**The Next Generation
Energy from Waste Facility
Eastern Creek**

Architectural Design Statement

27 March 2015

subject **The Next Generation – Energy from Waste Facility – Eastern Creek
Architectural Design Statement**

02 TYPICAL PRE-FABRICATED PALISADE FENCE  
SCALE 1:20

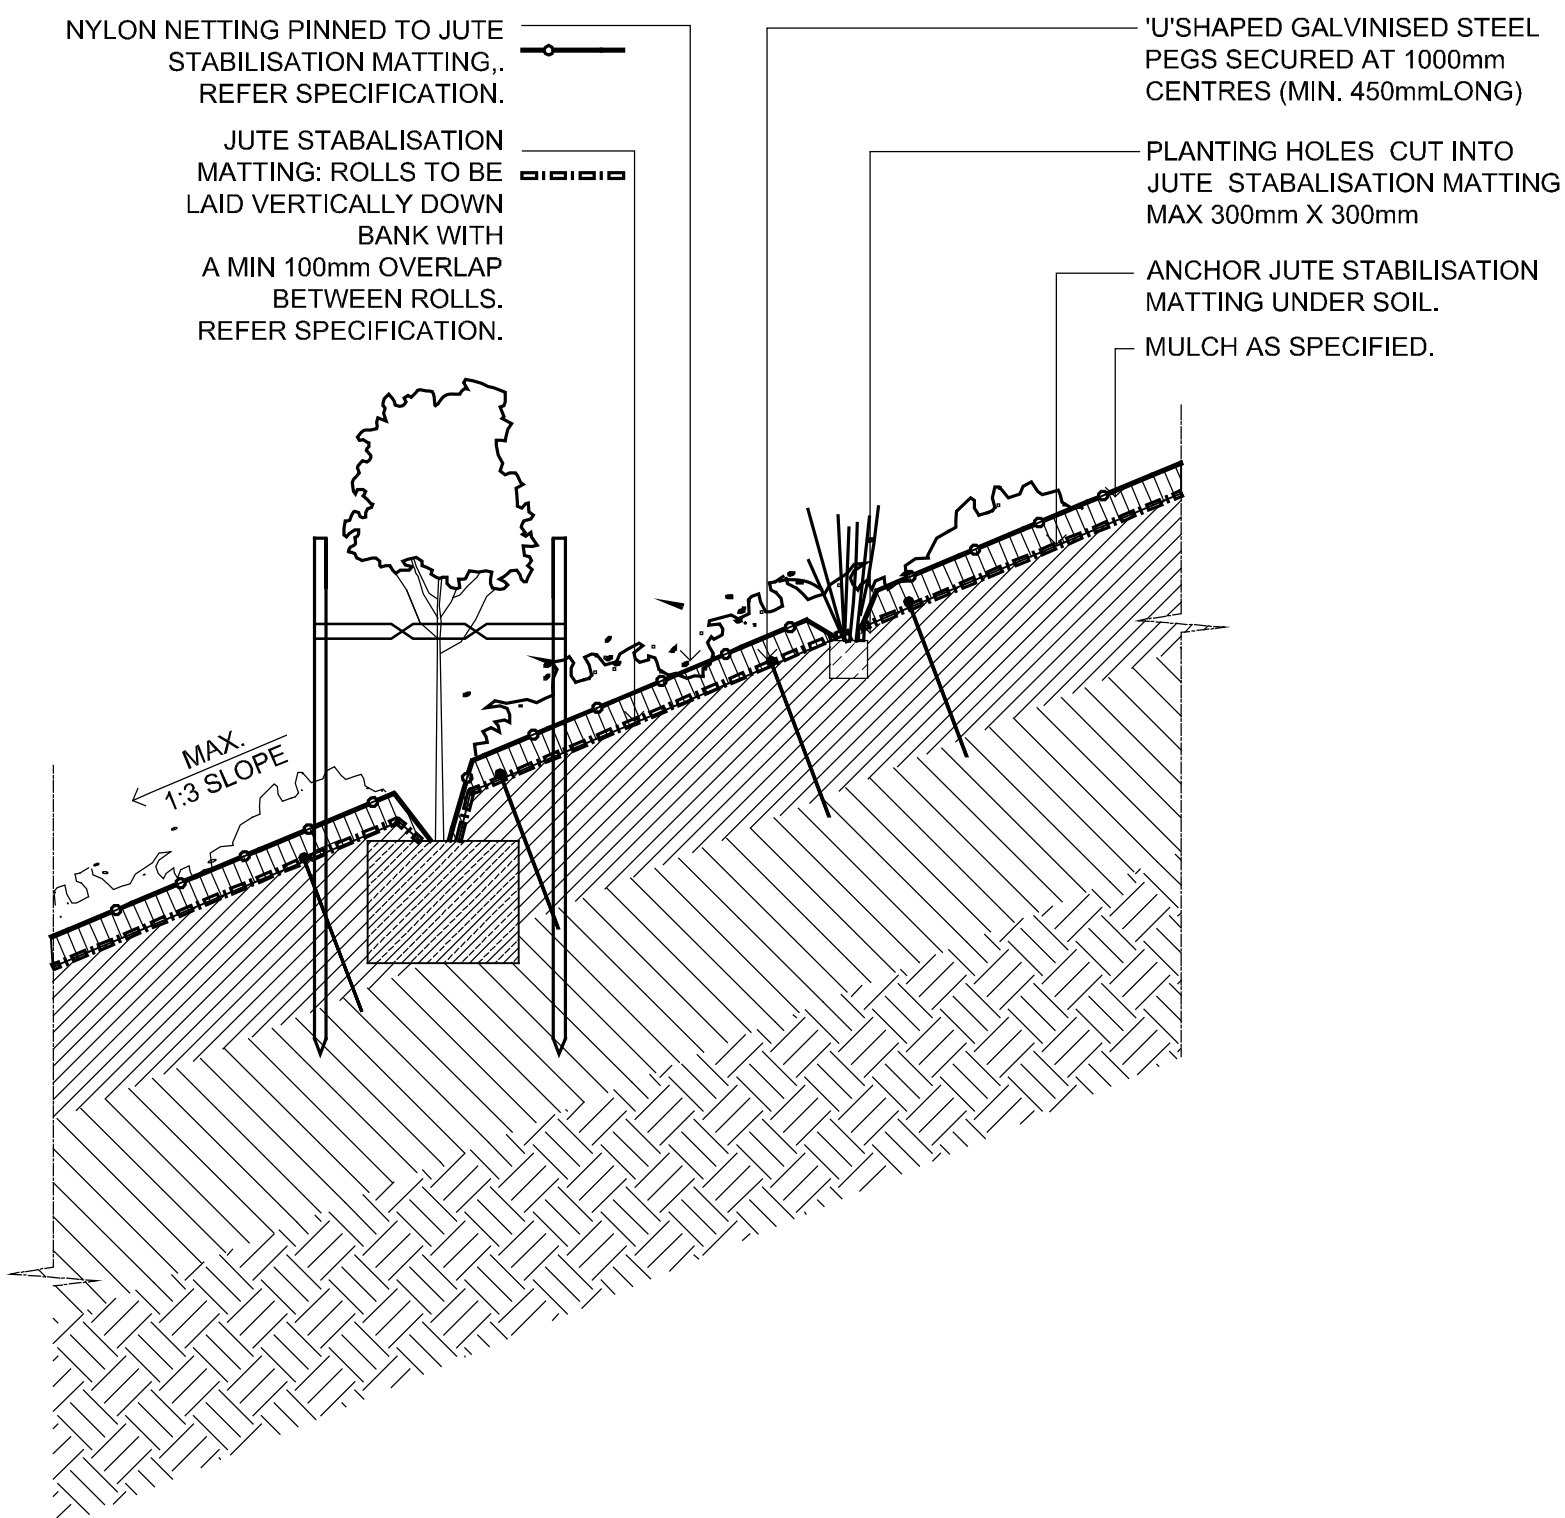
2. *The proposed flat roof form lacks architectural merit, elements including saw tooth elements, cantilevering components, roof overhangs should be incorporated into the design to ensure the building does not have the appearance of a series of “boxes”.*
3. *A revised schedule of materials is required to be submitted – this shall be a true representation of the proposed colours. The elevations are not reflective of the external materials colour sample. Copies of the manufacturer’s brochures are required to be submitted.*
4. *Details of any proposed fencing including elevations and details of materials of construction.*

Discussion raised a question about the nature of the perimeter fencing along the estate road. It was agreed that a palisade style fence with landscape buffer planting was a superior solution to the previously proposed precast walling and would be incorporated.

The functional requirements of the on site activity determine expanses of hardstand. Other peripheral areas of banking and non trafficable surfaces are treated with crushed rock, applied in contrasting colours to create pattern that enlivens the ground scape. Plant species selection responds to the need for reduced maintenance. Street tree planting along the north and south sides of the estate road creates a boulevard quality. Palisade style fencing at a height of 2.4m is applied along the north boundary of the TNG facility as well as the south boundary of the adjacent genesis facility. Hedge planting within the fence line creates a suitable visual screen.

A NORTH ELEVATION PART
1:200

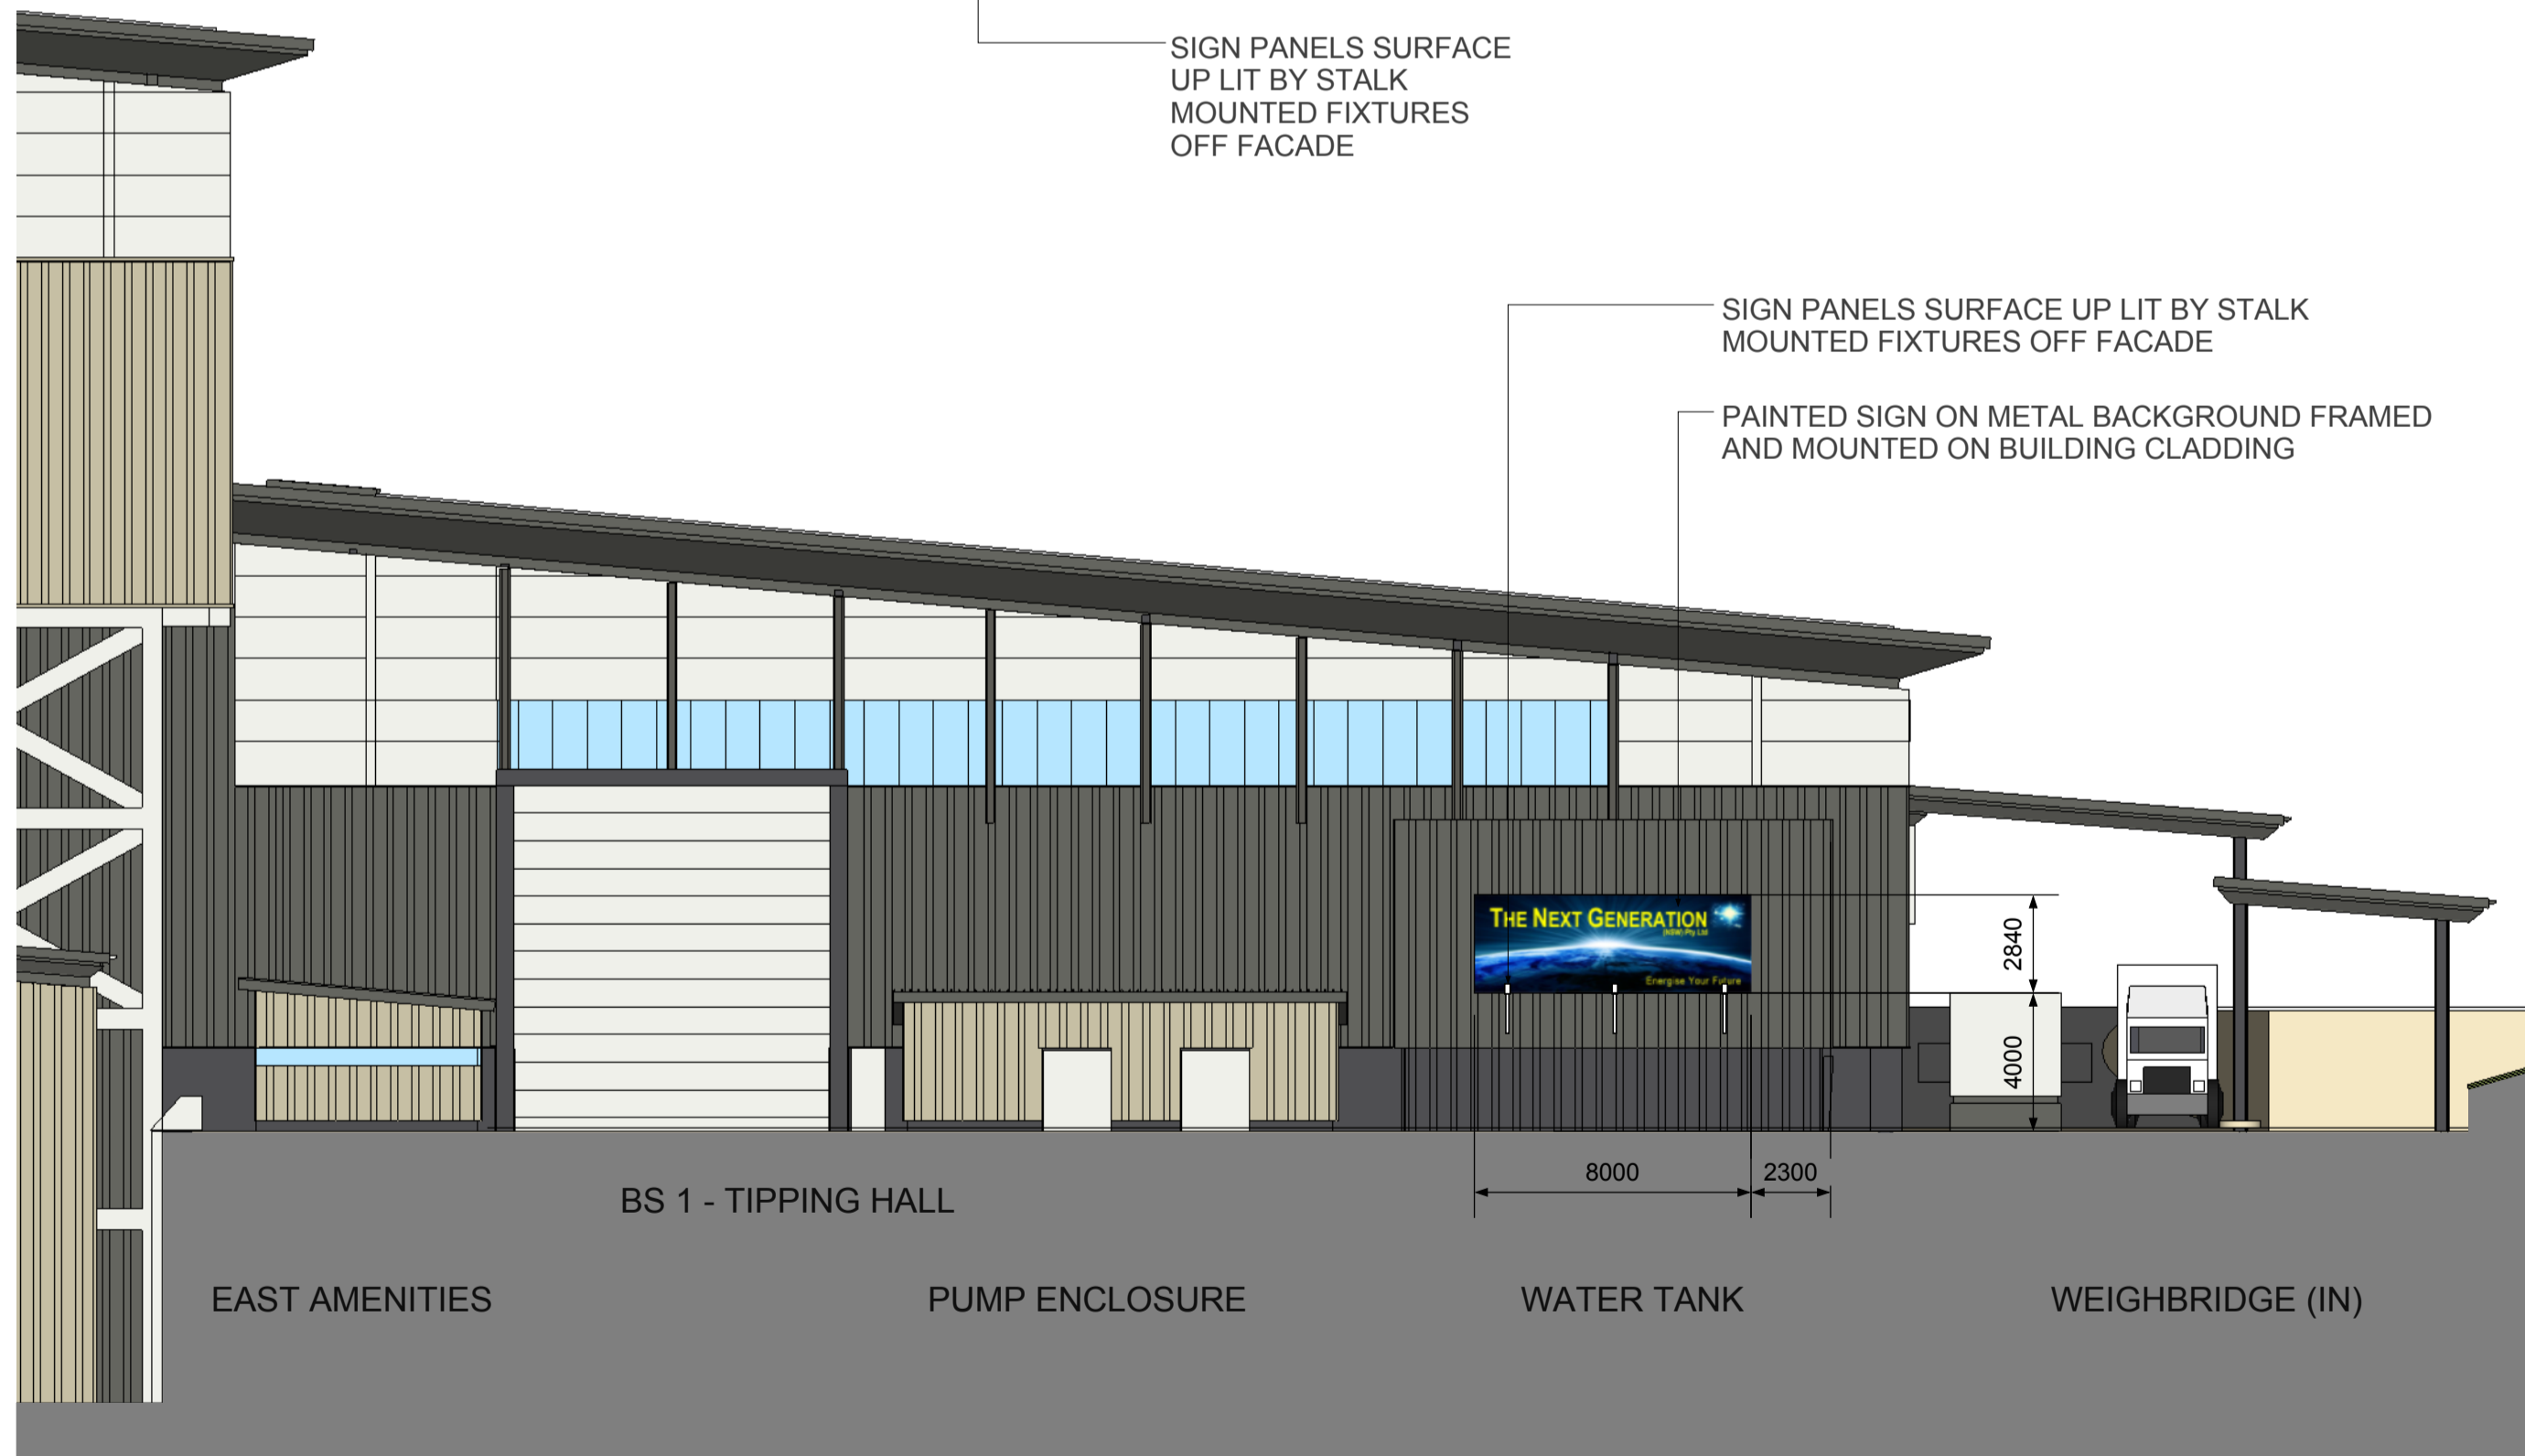
1. *The design of the building lacks architectural merit and has an appearance of a series of "boxes"; the design does not include any innovative or contemporary elements. The design should include elements to provide an improved façade such as use of masonry elements, the use of innovative metal work techniques such as perforated metals, and more glass elements.*

BC requested that the "blades" on the east and west elevations extend to finish lower than the current louvre opening. KTA hand marked up the drawings to illustrate the intended response. This was generally accepted by BC as a suitable means of breaking up the side of the building.

The horizontal parapet and “box” forms have been eschewed in favour of a series of mono pitched roofs that sleeve above one another and reinforce the north south axis of the building groupings. The pitching roofs of the Tipping Hall, Waste Bunker and Boiler House feature deep 2.5m eave overhangs with a metal panel fascia and soffit lining, which is profiled to create a dramatic shark nose edge. The façade junction with the eaves is given crisp definition through application of a 300mm

The east and west facades of the Tipping Hall feature a “Danpalon”, translucent polycarbonate glazing zone, to bring natural light and add further texture to the façade. Both east and west facades are further embellished with “Alucobond: clad metal blades which provide a pronounced third dimensional quality and link the façade cladding zones, whilst offering shade to the glazing zones. Formed concrete portals around the roller shutter entry points give visual strength and a scale in keeping with the overall composition.

KTA presented increased extent of "Danpalon" glazing, louvred zones and extension of metal blades within the façade to create greater façade articulation. BC agreed that this was a satisfactory result.
